## DECISION DELEGATED TO HEAD OF PLANNING

**Application No:** H20-0343-26      **Applicant:** Belmont UK

**Proposal:** Erection of 3 Dwellings - approved under H20-1258-25. Modification of Condition 1 to allow amendments to previously approved plans and removal of Condition 4 relating to Pilkington Privacy Glass

**Location:** The Orchards Broadgate Sutton St James

SECTION A-A

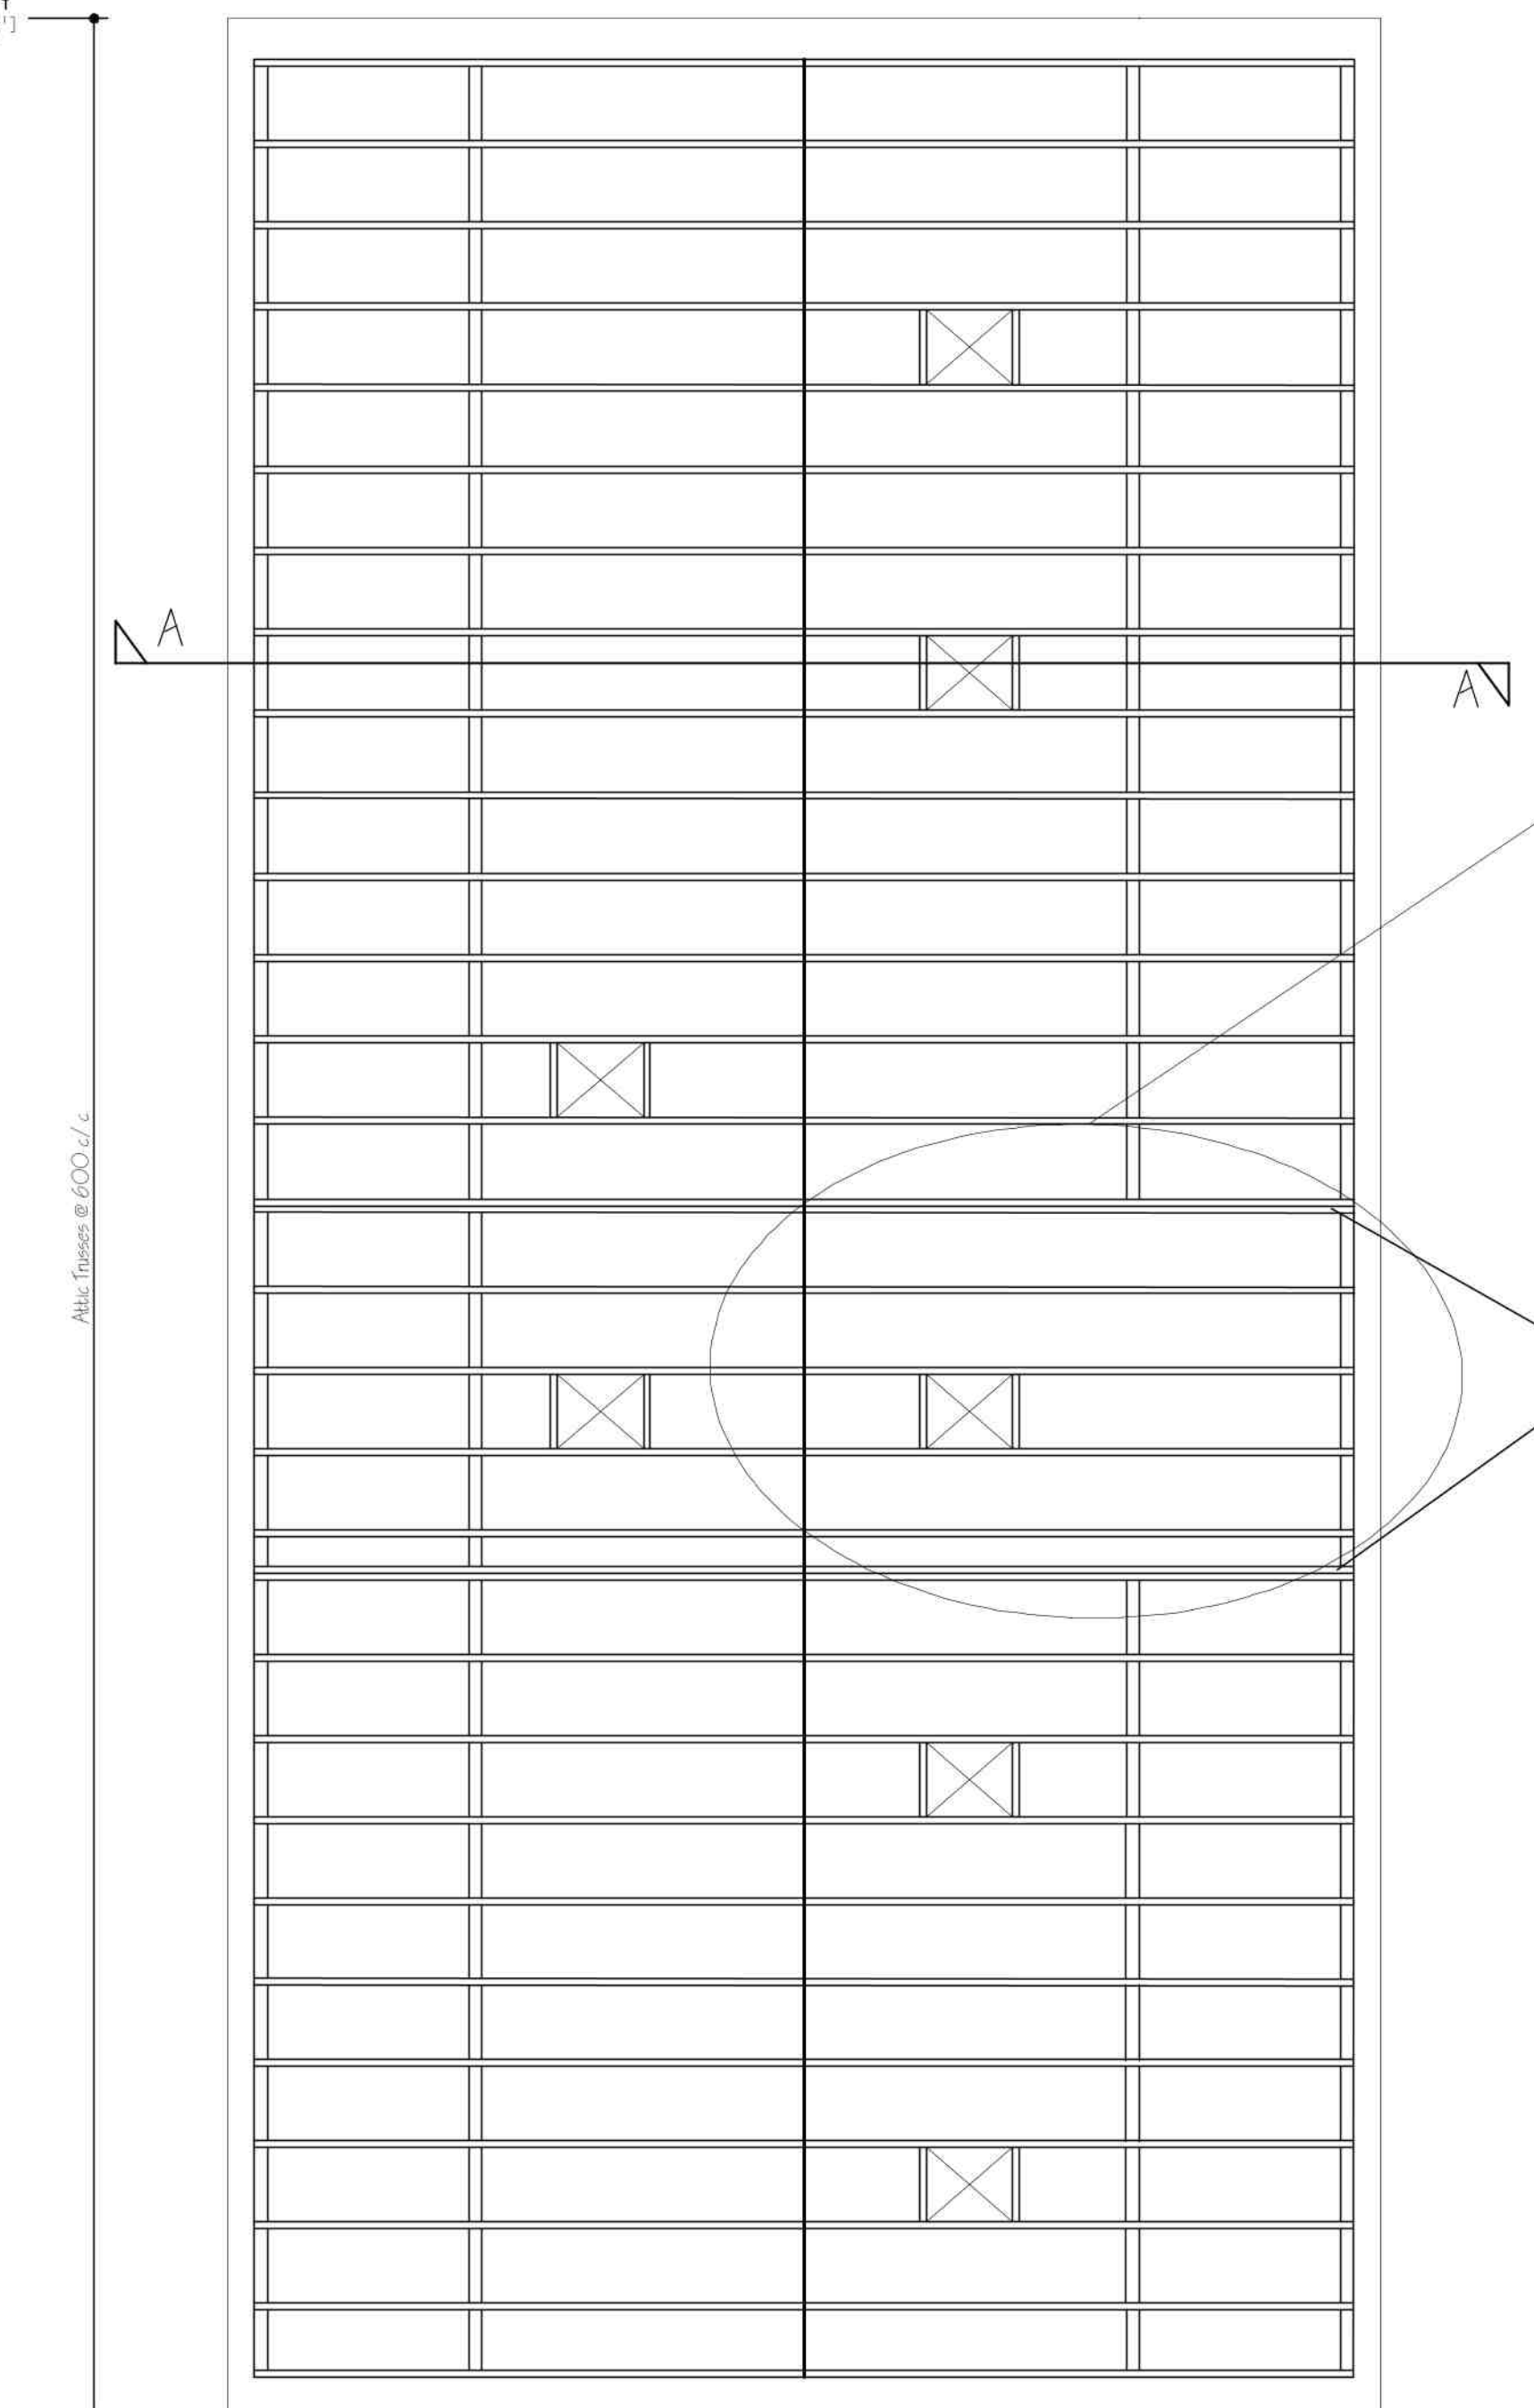
The southern side elevation of plot 3 is between 2m and 3m from the boundary with Homelea which is the nearest dwelling to the south. The planning statement refers to a property to the east; however, it is presumed that this means Homelea.

Although there is a close boarded fence between the dwellings, it is nonetheless considered that there would be a degree of overlooking if no obscure glazing is proposed. For example, there are habitable room windows proposed at the ground floor level including a kitchen and a playroom. The separation distances would be very small between the properties, and it is considered appropriate to retain the requirement for obscure glazing on these windows.

The planning statement sets out that only a very tall person would be able to see out of the room windows at the first-floor level. The LPA considers that 1.7m is not particularly tall and it is considered that occupants could see out of the windows. The roof lights would be approximately 5m from the site boundaries beyond which there are neighbouring gardens. As set out previously, it is considered that there should be a separation distance of 10m from habitable windows such as bedrooms and garden boundary to prevent an unacceptable degree of overlooking. The smaller separation distance was only accepted in this instance due to the inclusion of condition 4 which was considered a reasonable compromise and would have prevented the need for the applicant to completely revised the plot layout.
